Local Policing Support Team

Our Ref: NW/ARU/17/11D

RE: Cinders Lane Nursery & works to R/O Cinders Lane Yapton. BN18 0JJ

Thank you for your correspondence of 4th June 2019, advising me of an, 'Approval of reserved matters following outline consent Y/5/17/OUT for 51 No dwellings. This application affects a public right of way' for which you seek advice from a crime prevention viewpoint.

PLOTS 39-46 | GROUND FLOOR PLAN
 DEVELOPMENT AT:
 CINDERS LANE
 YAPTON
 BN18 0JJ

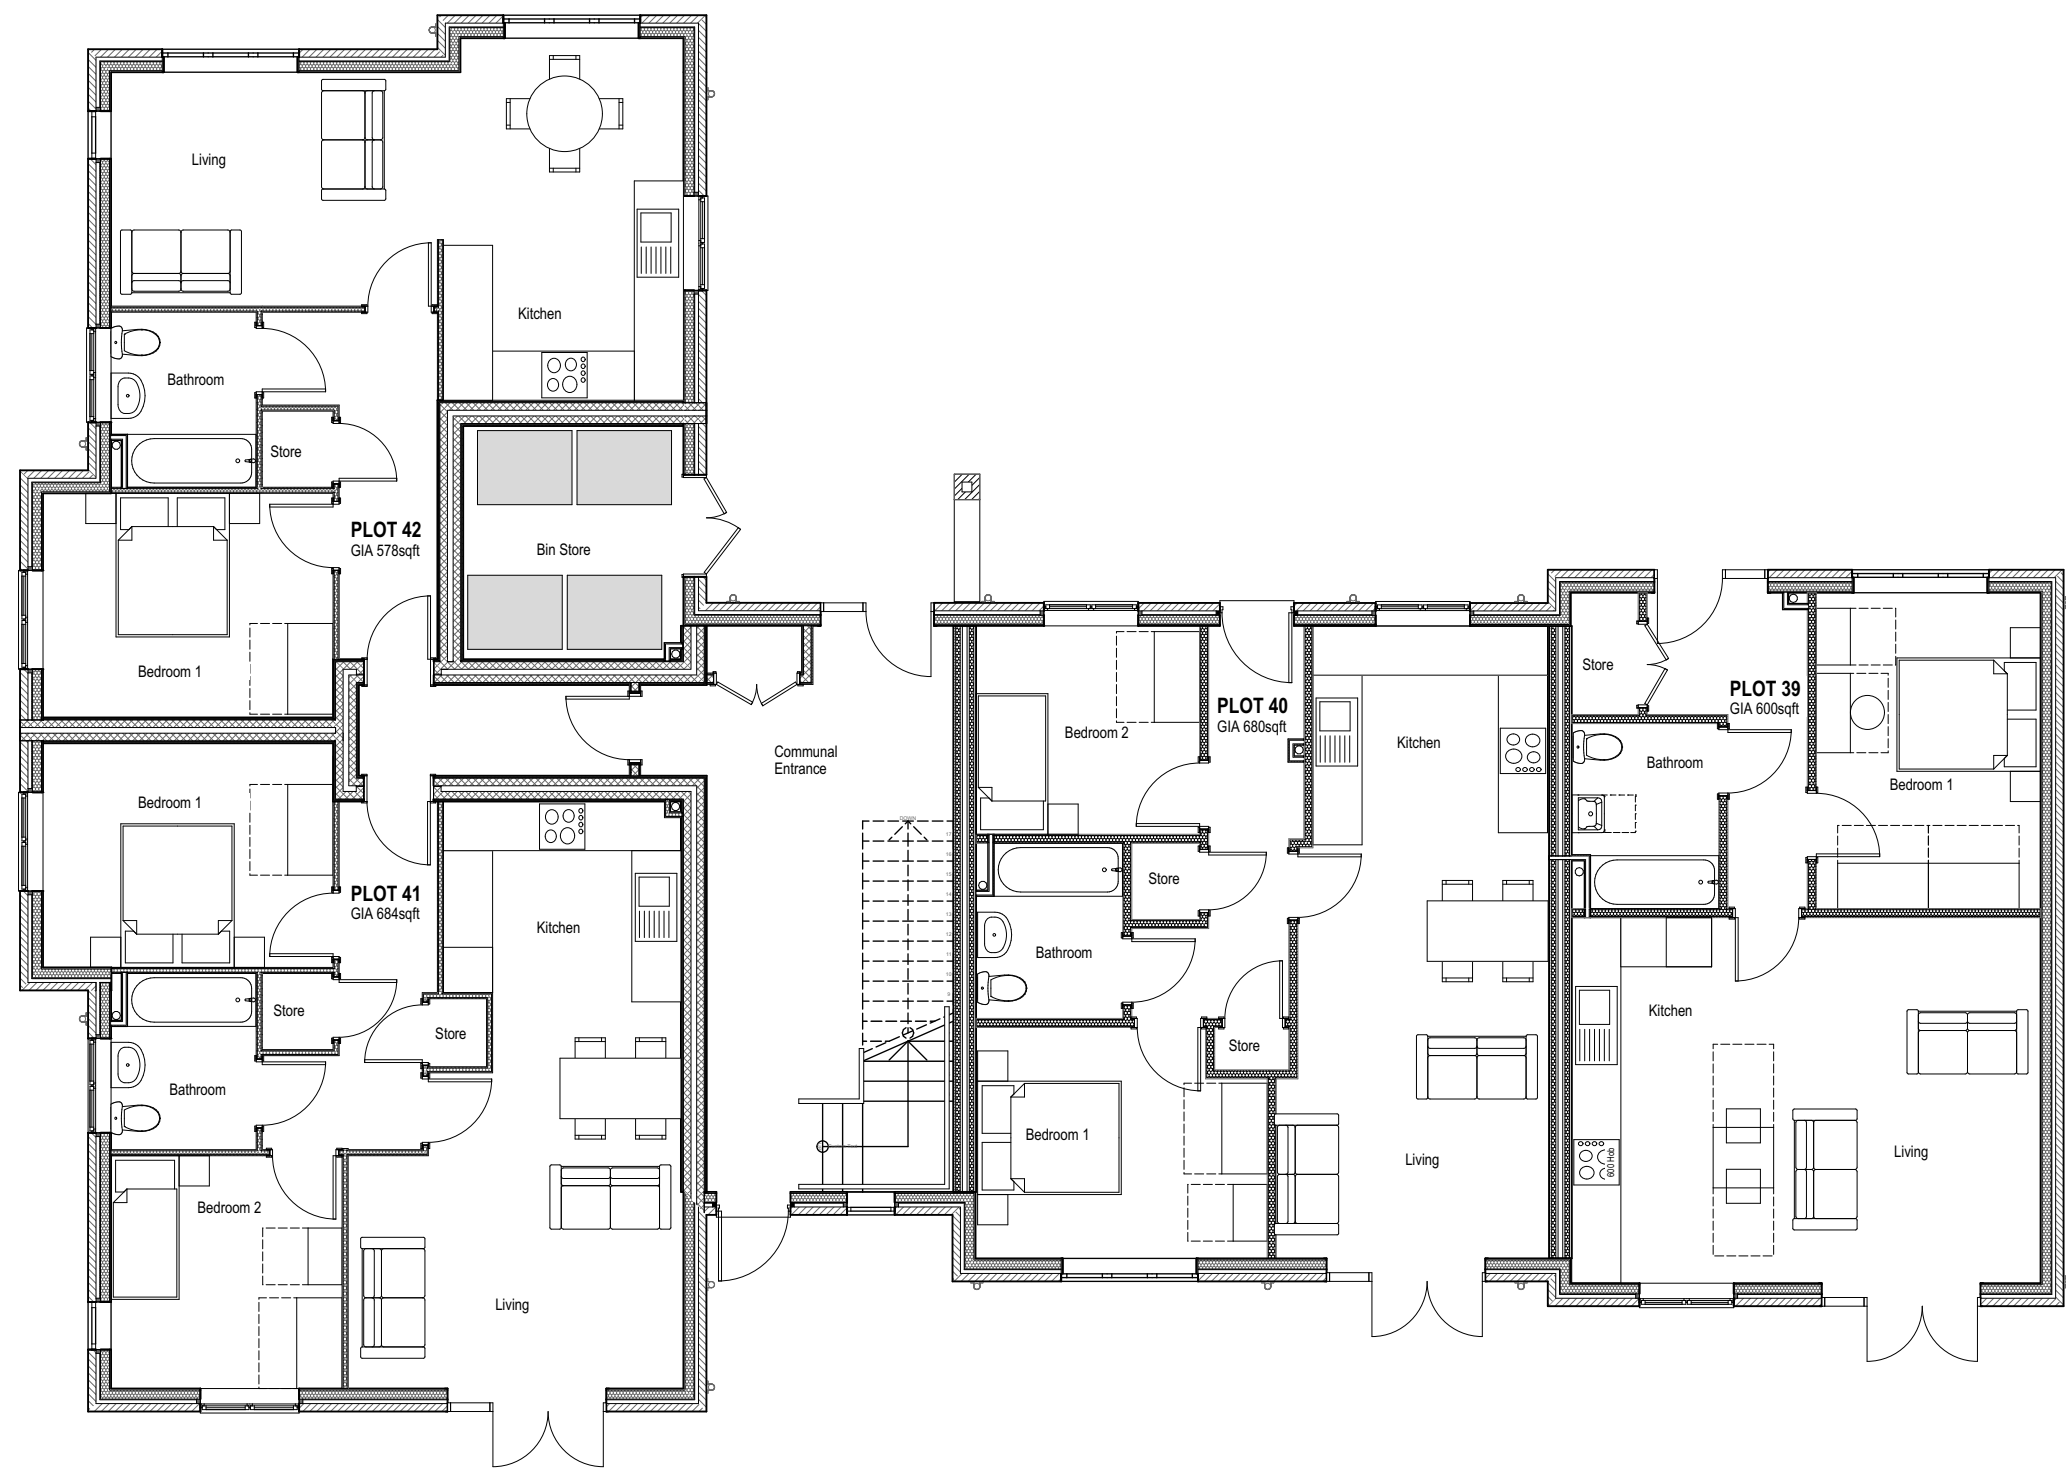
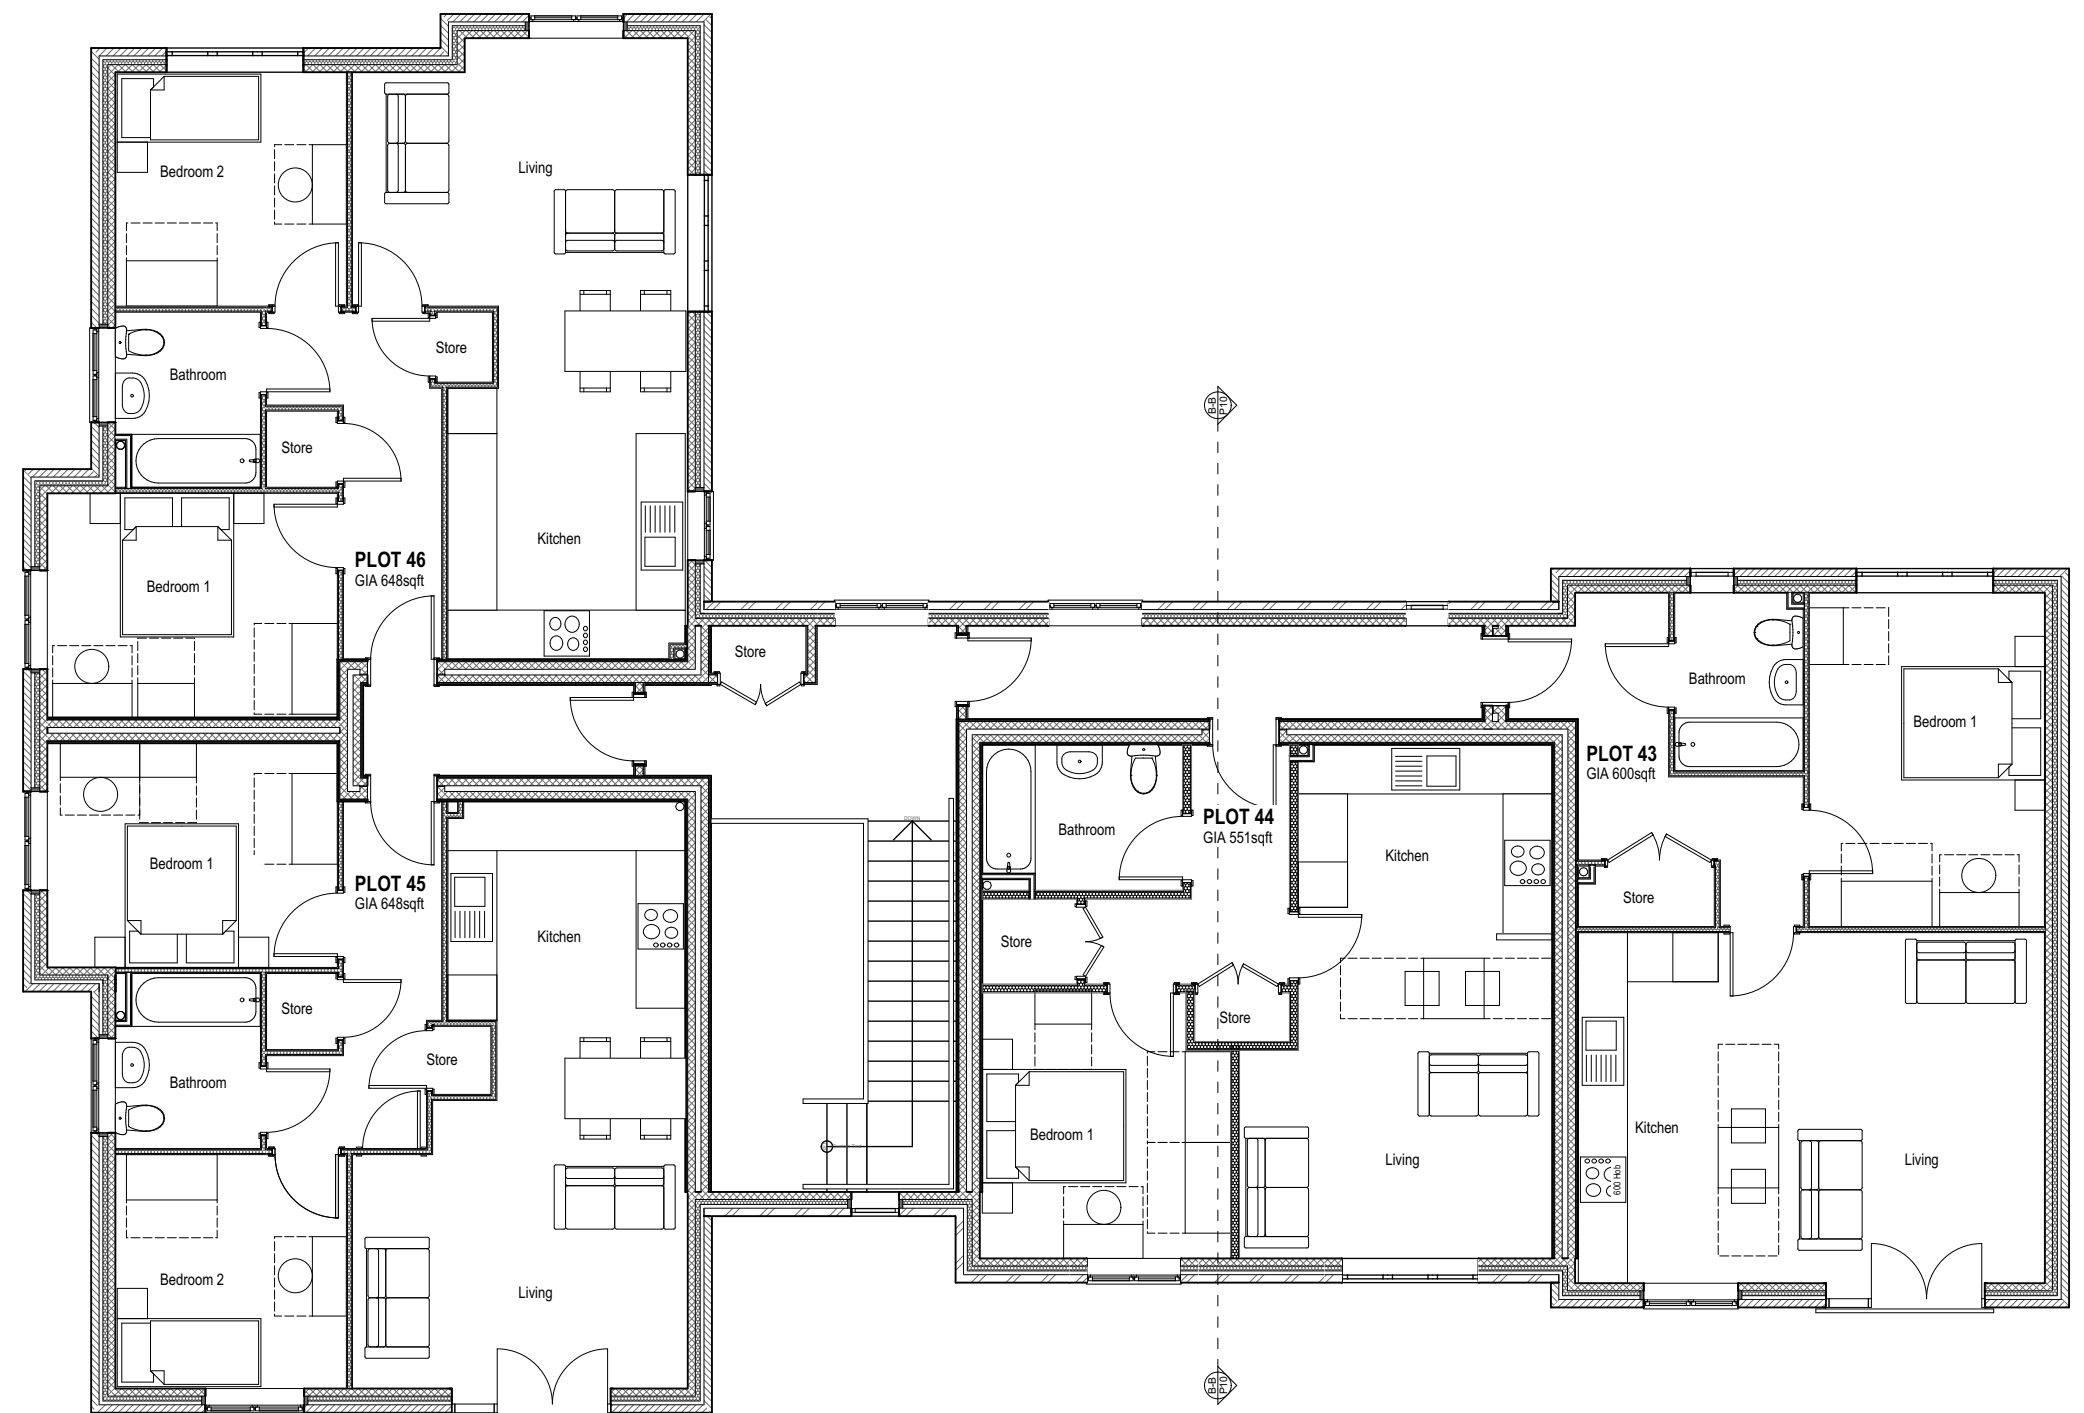
In addition, I note previous plots (numbers 40-47) which are flats, have now changed to plots (39-46) on drawing number 19.14. P101 U, dated July 2018.

My comments remain as previous and I note the addition of an external cycle store for the flats. From a crime prevention view point, I refer to Secured by Design Homes 2019 chapters 56.1 to 57.1 (found at www.securedbydesign.com) and recommend that external cycles stores are either brick built and with a roof, together with a secure single door meeting Section 2a paragraphs 21.1 to 21.21 of SBD Homes 2019 and have internal lighting.

The lock should be fitted with an internal thumb turn as a means of escape, to prevent persons from becoming trapped inside. There should be no windows.

Alternative external cycle stores with clear with transparent materials such as polycarbonate or strengthened glass and with a roof, located within view of an active room and within 50 metres of a primary entrance door can be used together with cycle racks or Sheffield hoops meeting the criteria within the above Chapters.
